# Rezoning Transportation Analysis

Petition Number: 2022-160

Date	Description
02-23-23	First Review (PDM)
03-23-23	Second Review (PDM)

RZ1.00

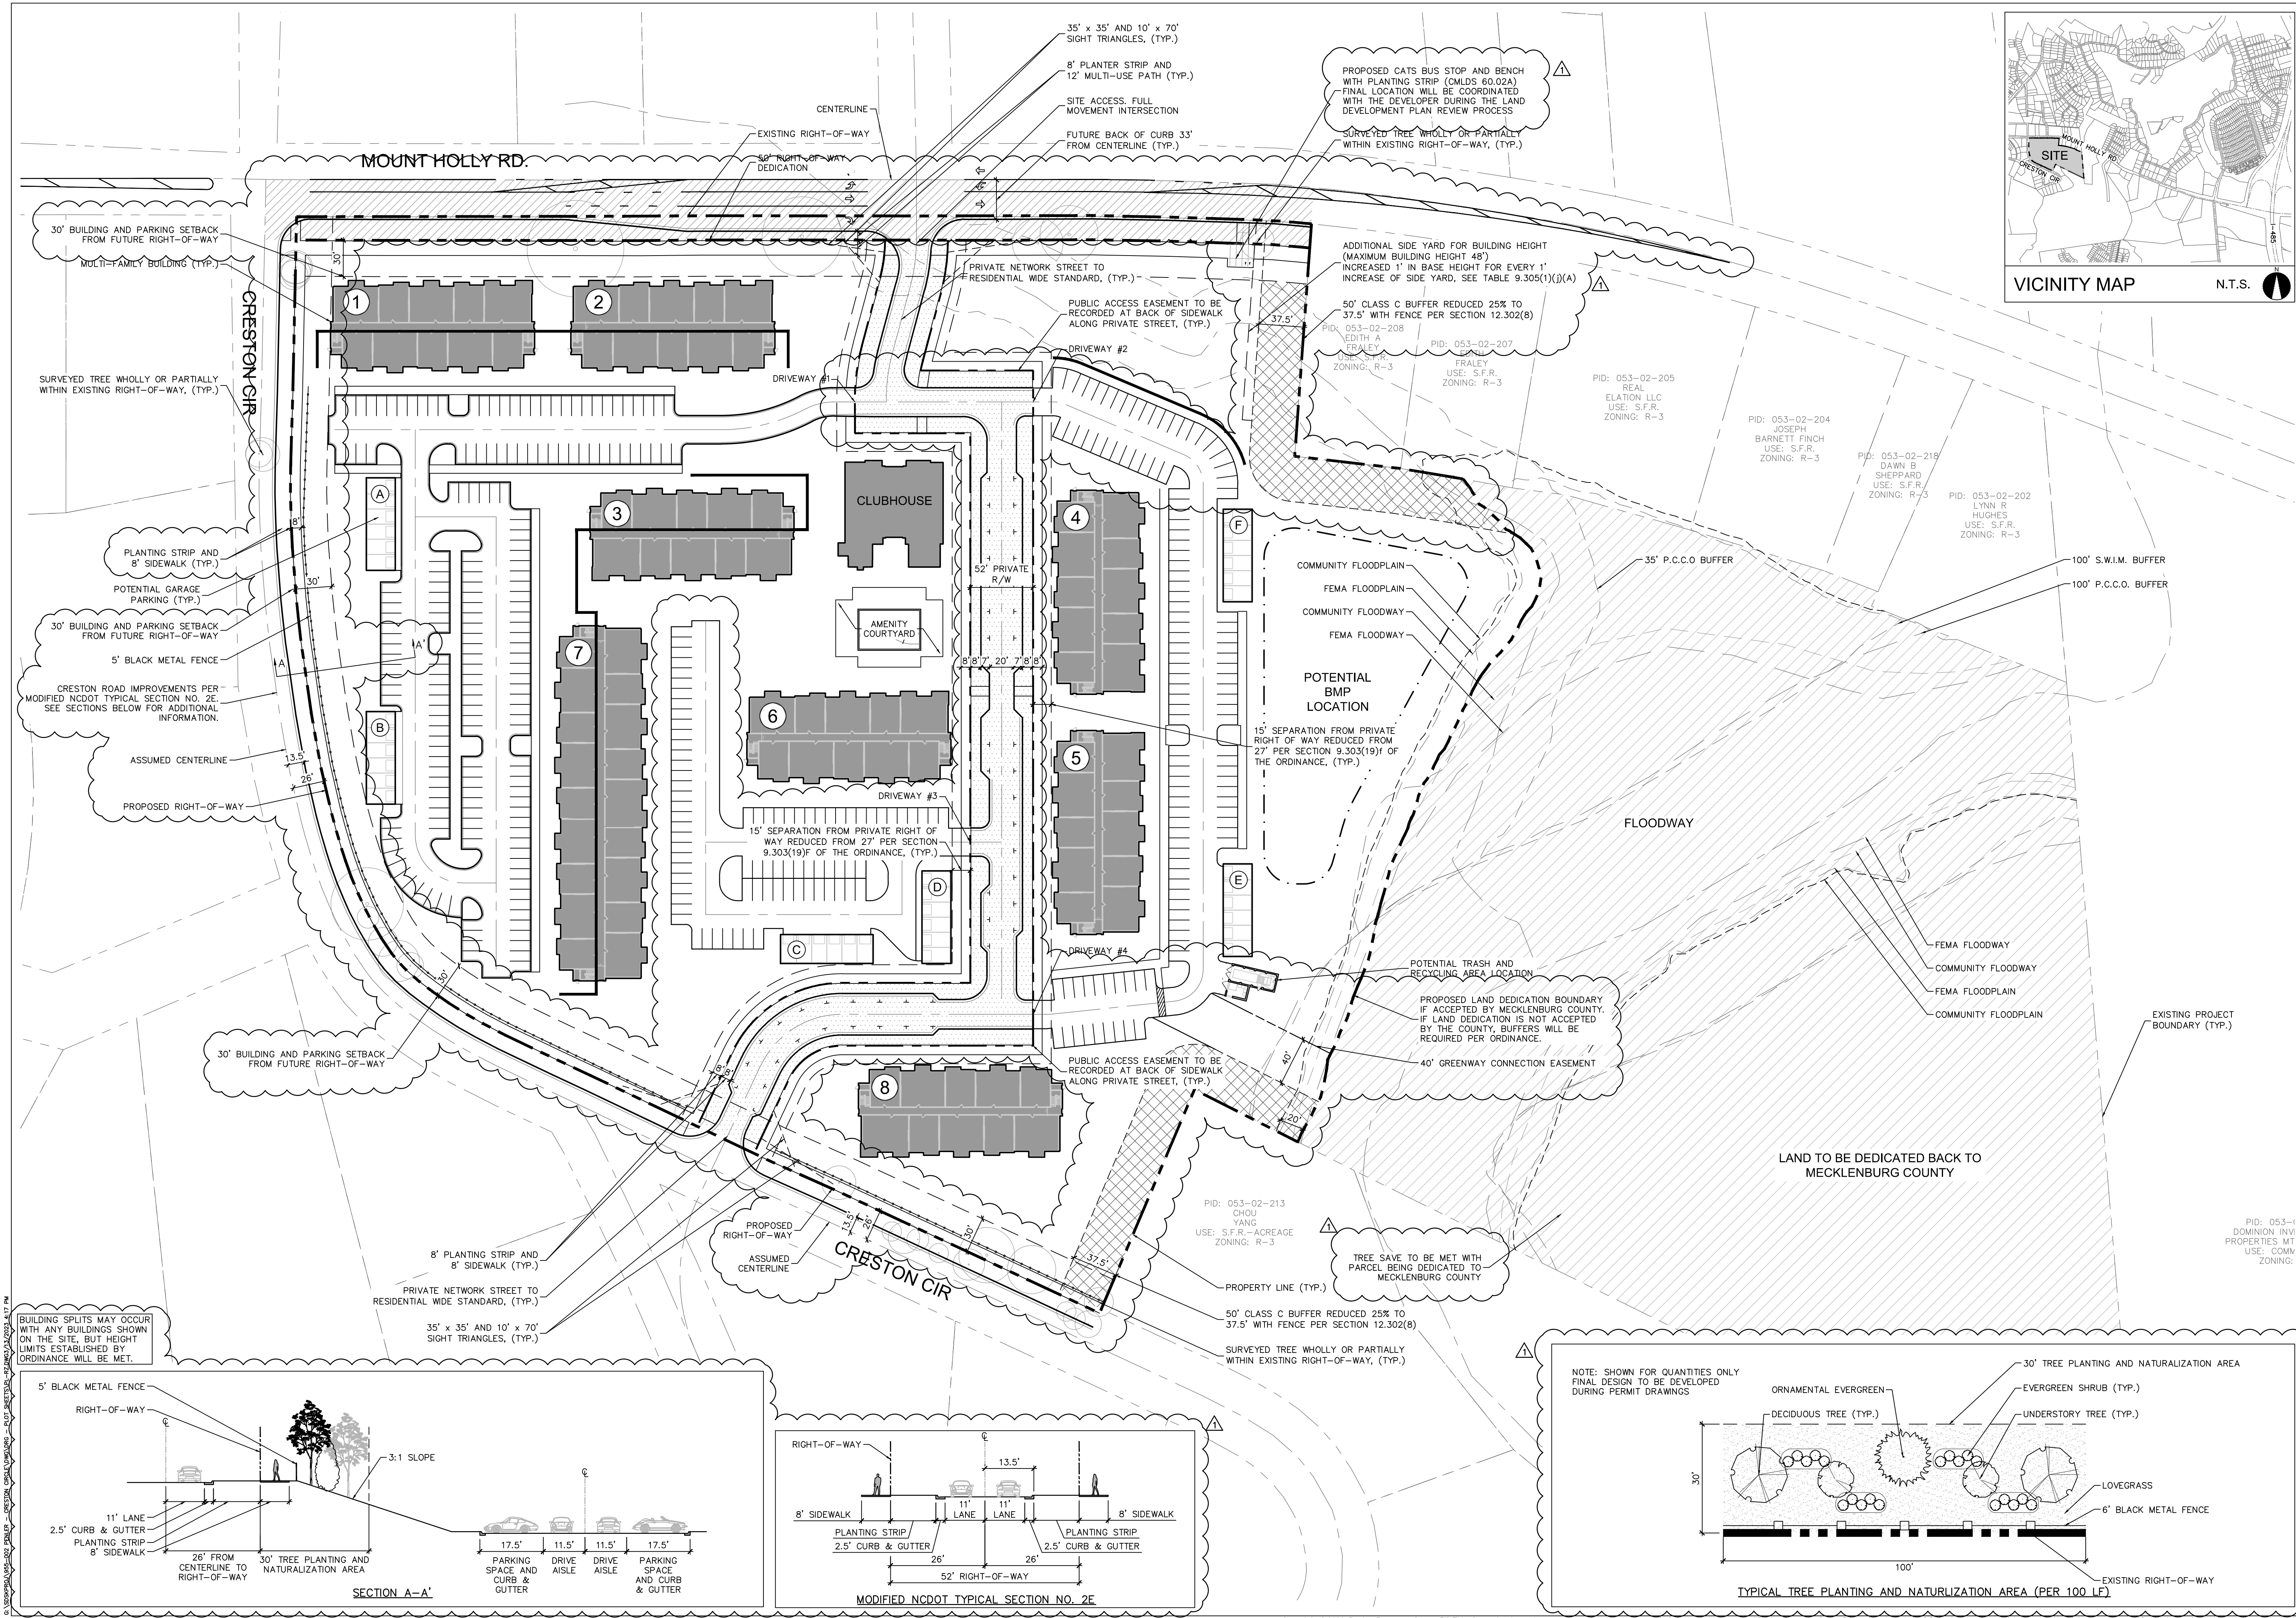
- a. **Mount Holly Road:** Location of curb and gutter to be installed at 33 feet from roadway centerline to accommodate the Charlotte Streets Map roadway typical section of a four plus lane avenue with shared use path.

**UPDATED COMMENT 3.23.2023:** Future back of curb needs to be show at 33ft for entire Mount Holly Road frontage for planning purposes.

**Creston Road:** Location of curb and gutter to be installed at 17.5 feet from roadway centerline in accordance with the Local Residential Wide typical section (CLDSM U-03).

Label and dimension the curb and gutter from the centerline for each road on the site plan.

4. Per coordination with NCDOT, revise site plan and conditional notes to commit to upgrading Creston Road to meet minimum NCDOT standards from Mount Holly to the proposed site access. Reconcile conditional note 3.e to reflect a Local Residential Wide typical section (CLDSM U-03) or equivalent NCDOT standard.

**UPDATED COMMENT 3.23.2023:** Revise cross section to CLDSM U-03 for Local Residential Wide.

**UPDATED COMMENT 3.23.2023:** Remove or modify the proposed phasing for the development (Note J). Creston Road improvements need to be completed prior to first CO for the site, or a more balanced phasing plan needs to be proposed. The current proposed phasing based on CO for building 8 leaves too much public infrastructure work outstanding for the last building based on the overall project scope, and it is not proportional.
